**Wincote**

**Design and Access Statement Addendum**

1.1 This document outlines the Minor Material Amendments to the previous application at Wincote, Cow Lane, Steeple Aston, Oxfordshire. OX2 4SG.

Planning
Proposed
North & South Elevations

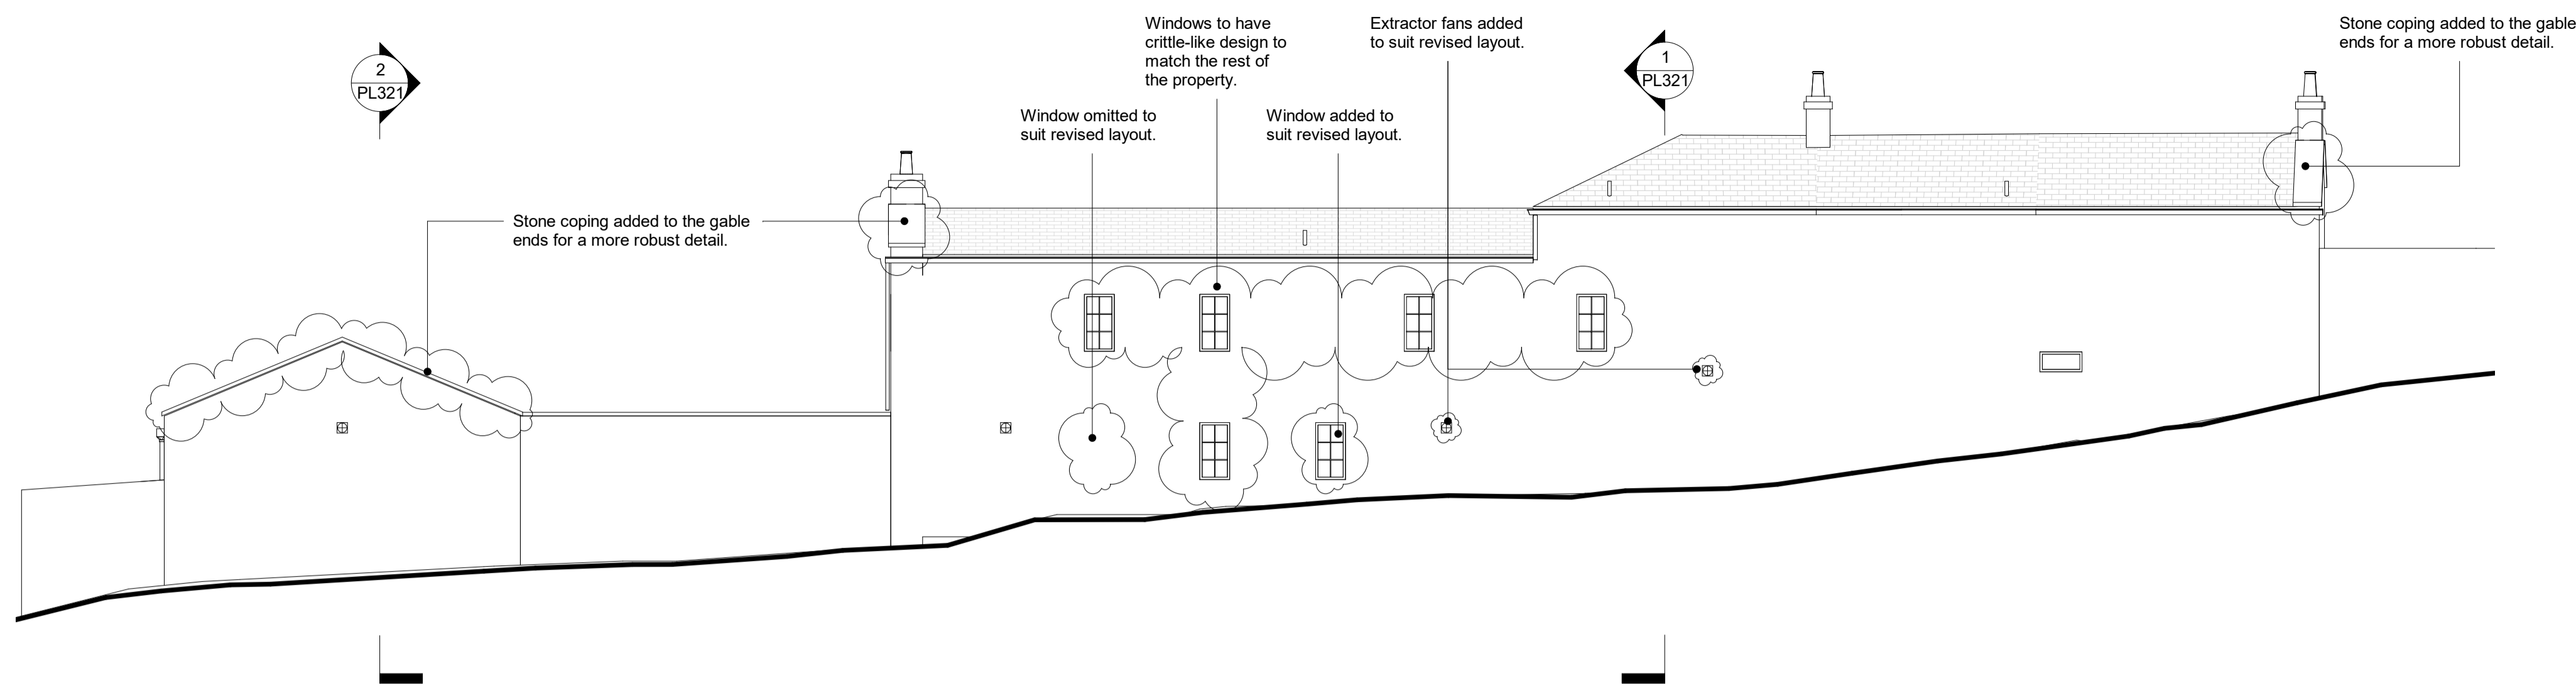
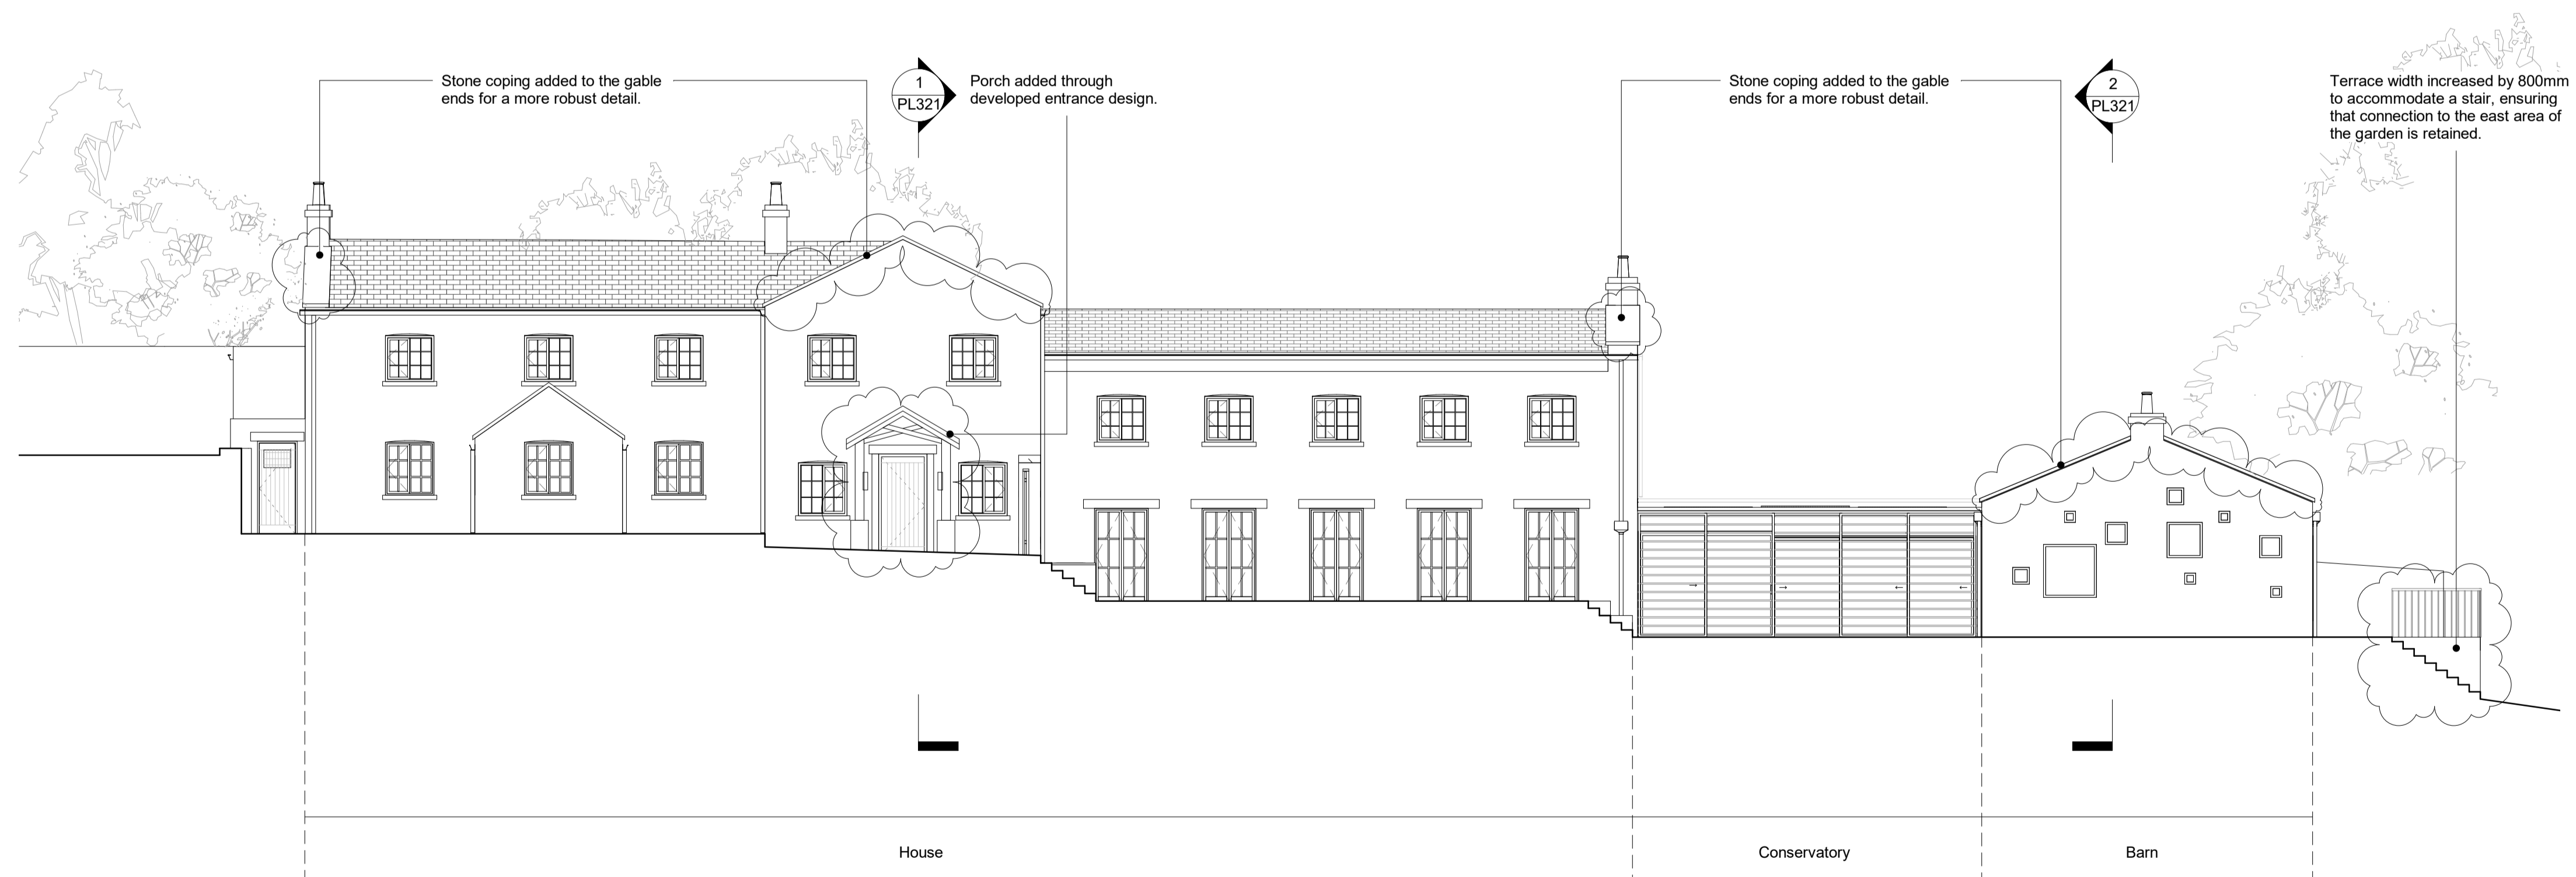
#### **4.1 Amendment to North Elevation**

4.1.1 It is proposed to move one window in the north elevation to suit the developed layouts.

4.1.2 The window style in the north facade to match the rest of the property.

#### **4.9 Amendment to the gable end roof design**

4.9.1 It is proposed that the gable ends will be capped with a stone coping to create a more robust detail.

Planning
Proposed
Section BB & CC

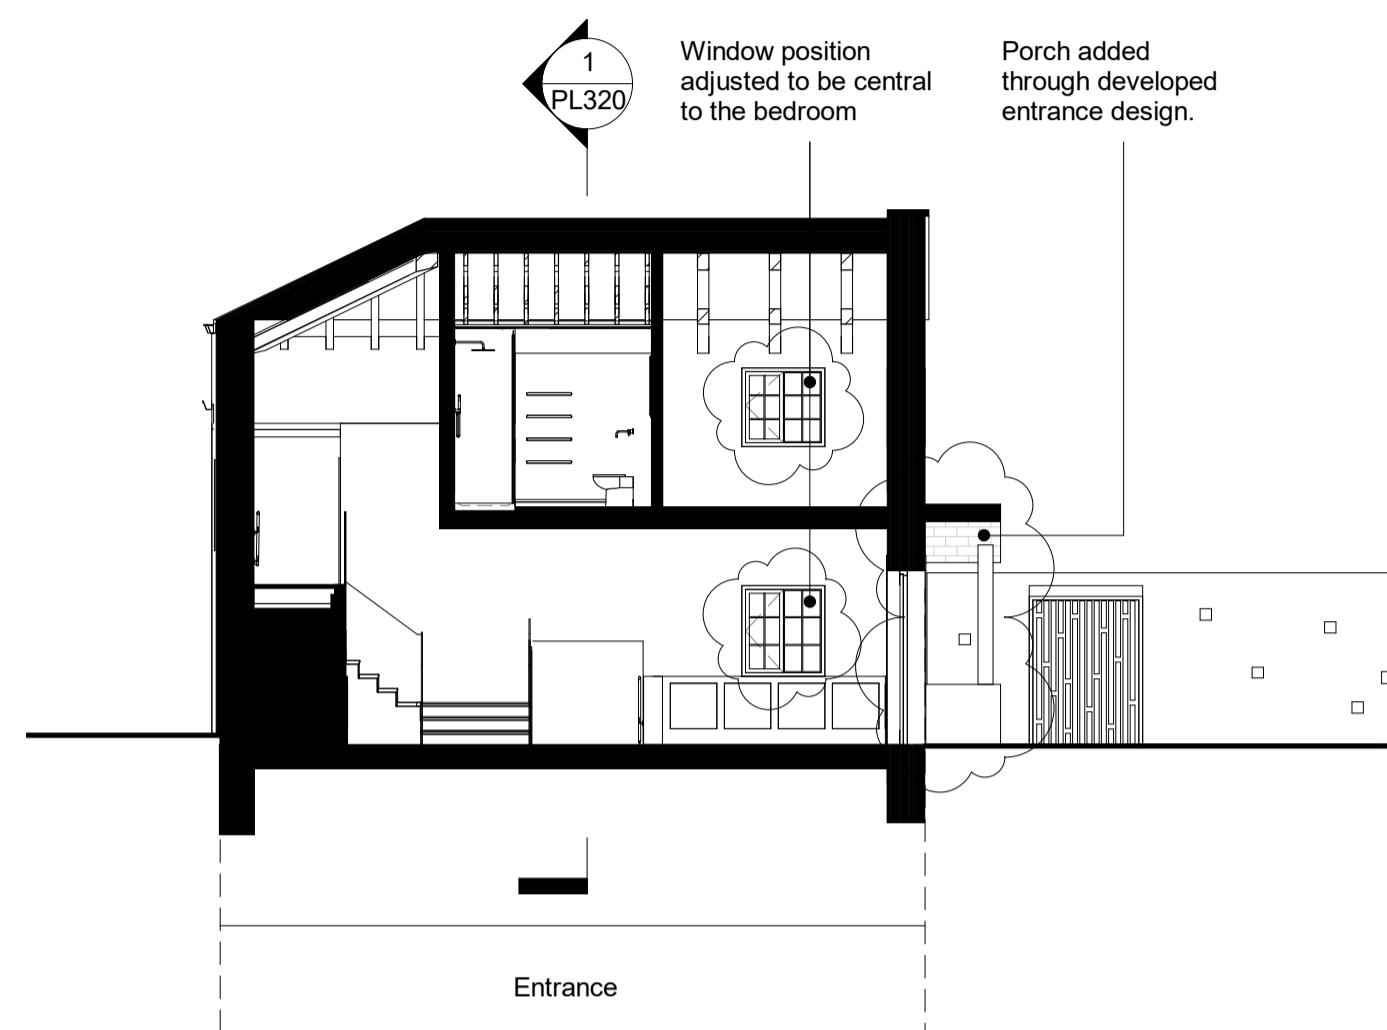
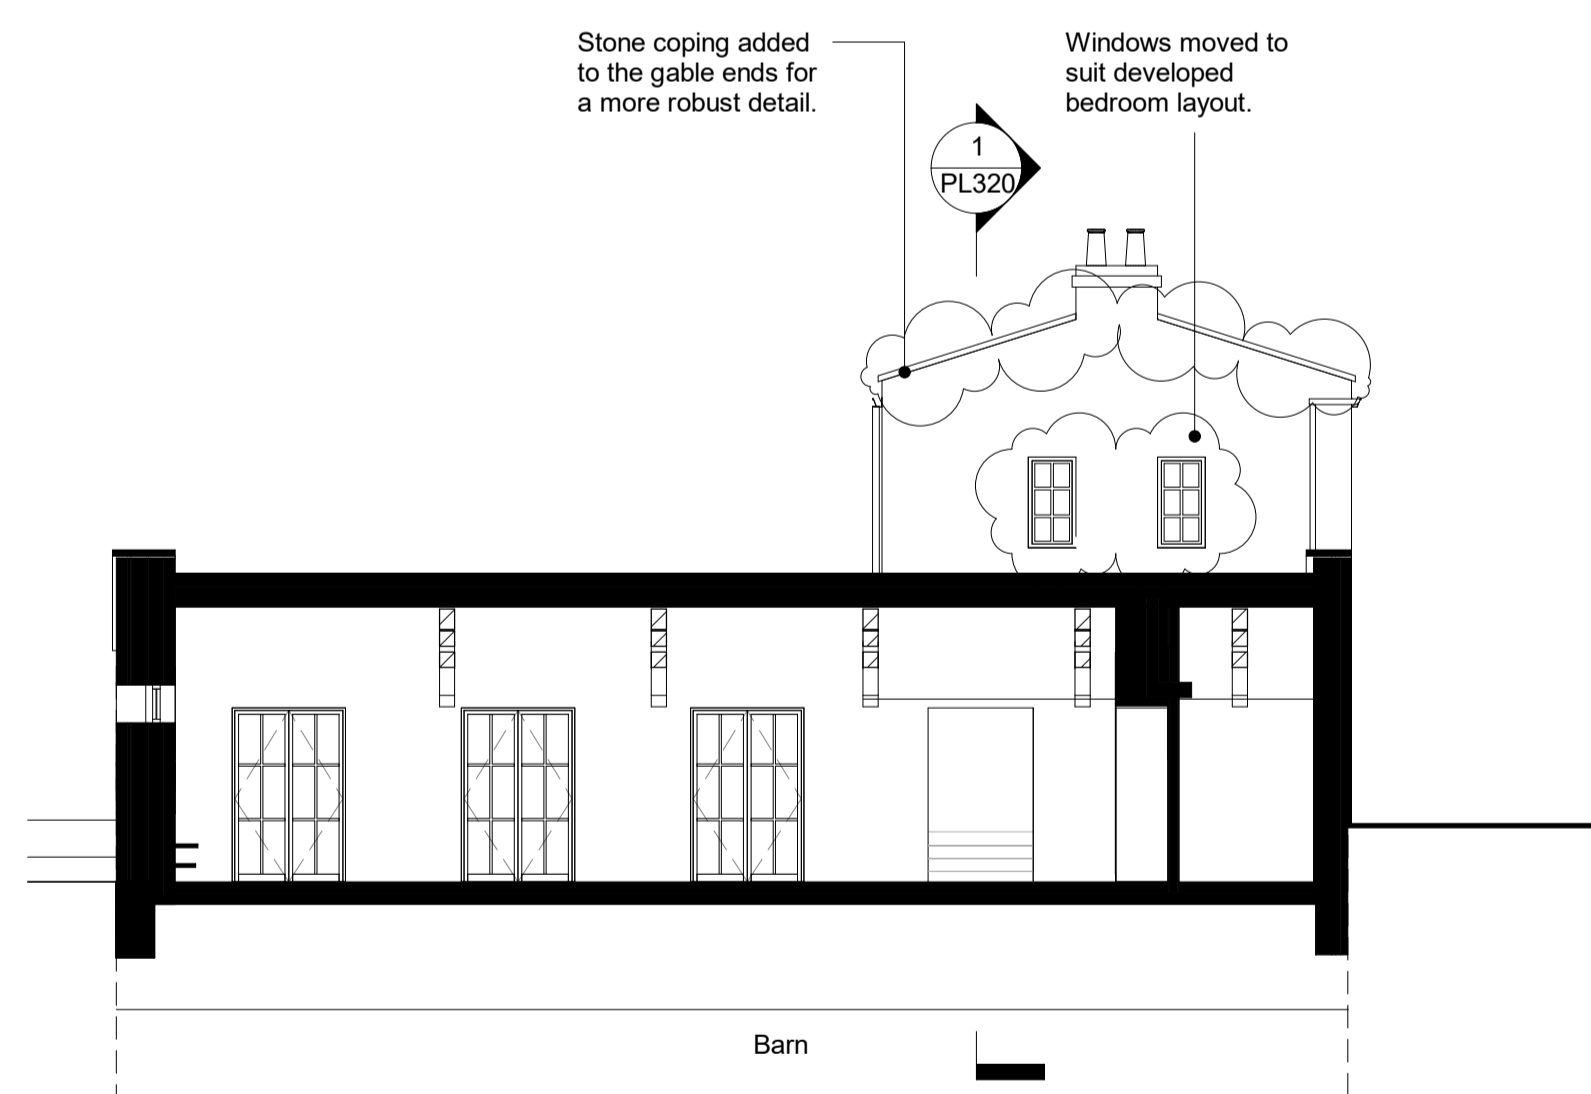
#### **4.8 Amendment to the layout of spaces along the east wing ground floor corridor.**

4.8.1 Revised layout provides increased storage, better connectivity to the first floor master bedroom and a more usable living space.

Planning
Proposed
Section AA

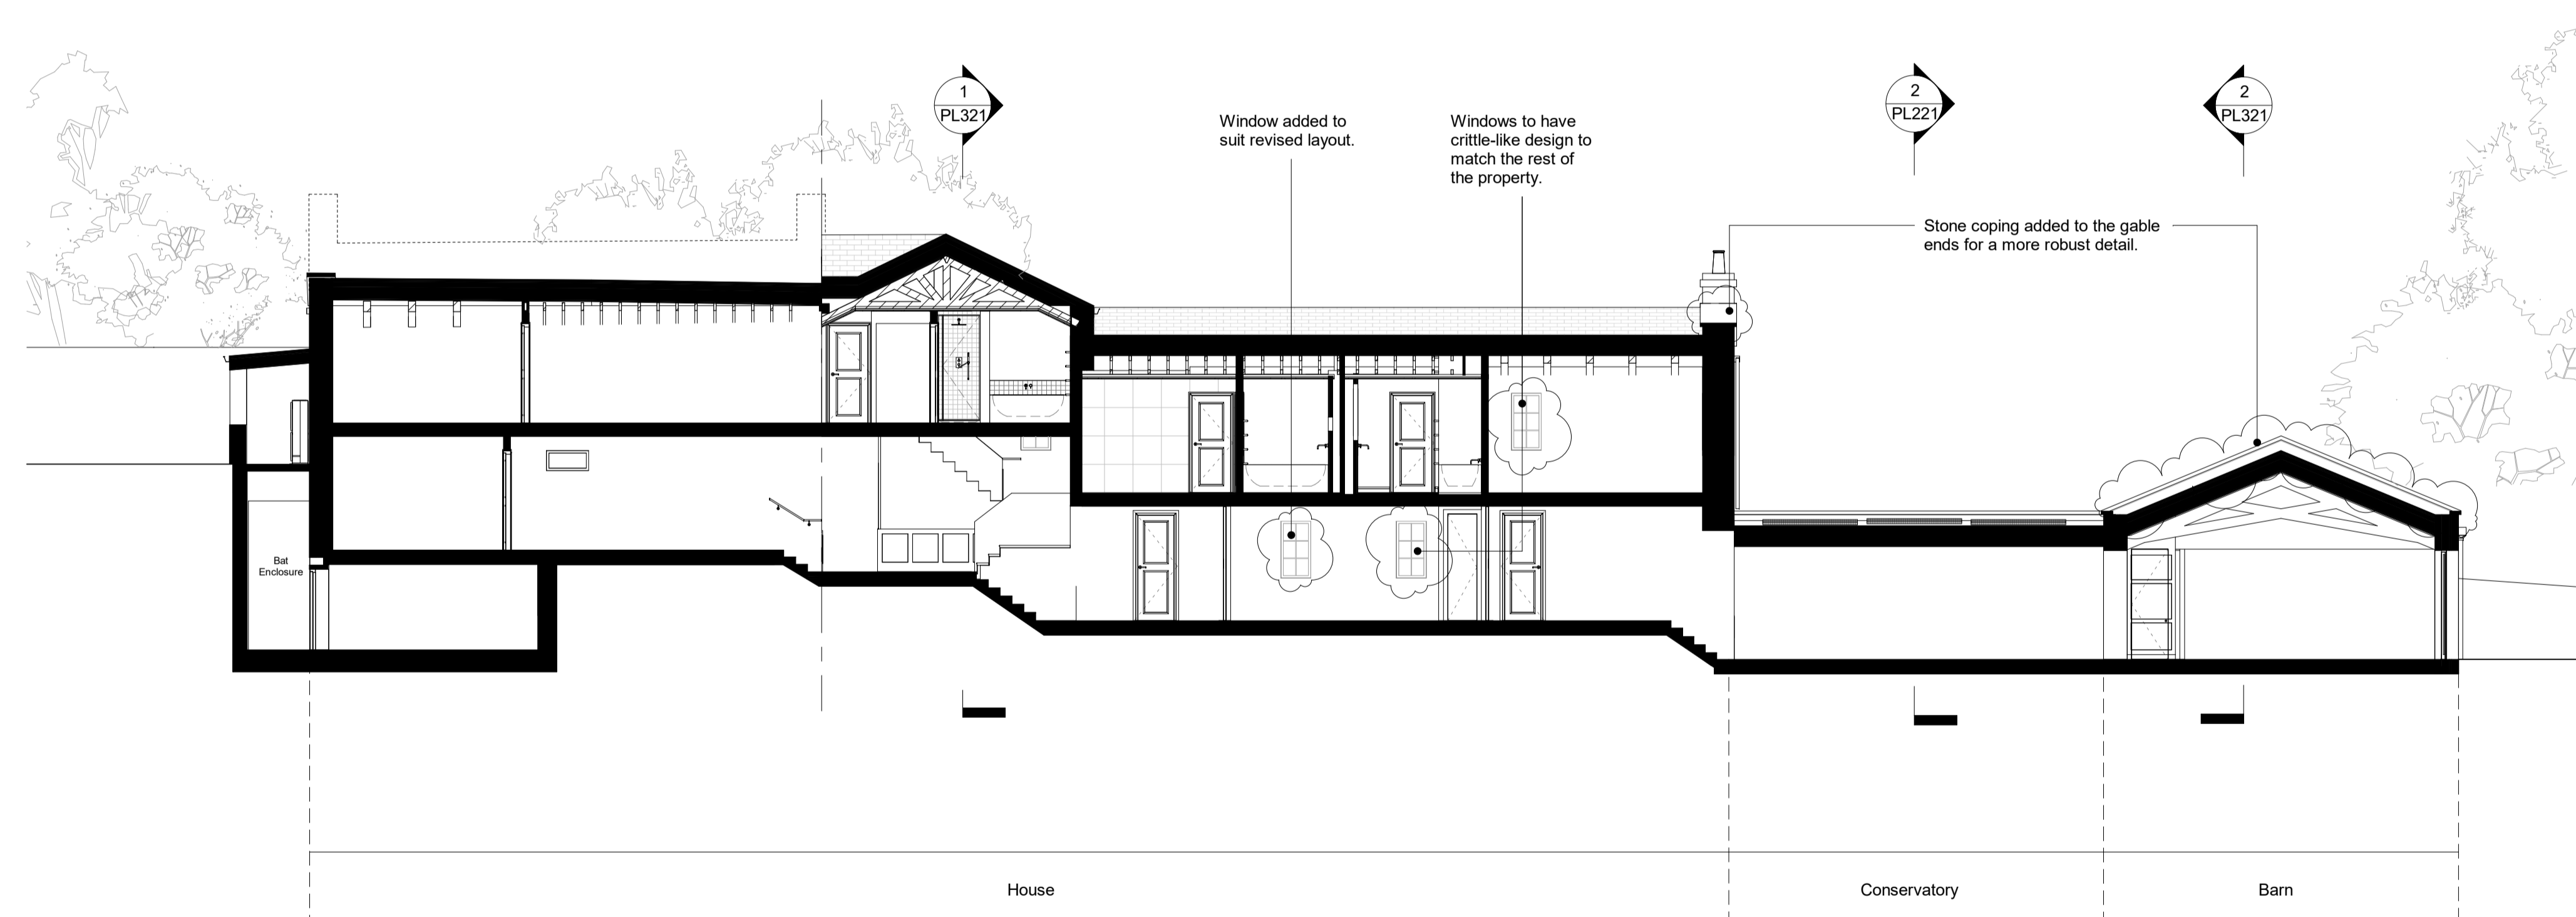
#### **4.3 Amendment to the footprint of the barn building**

4.3.1 It is proposed to increase the length of the barn by 1m to the south to accommodate the resolution of details to the fireplace, flue, kitchen and pantry design without having a detrimental impact on the consented living spaces.
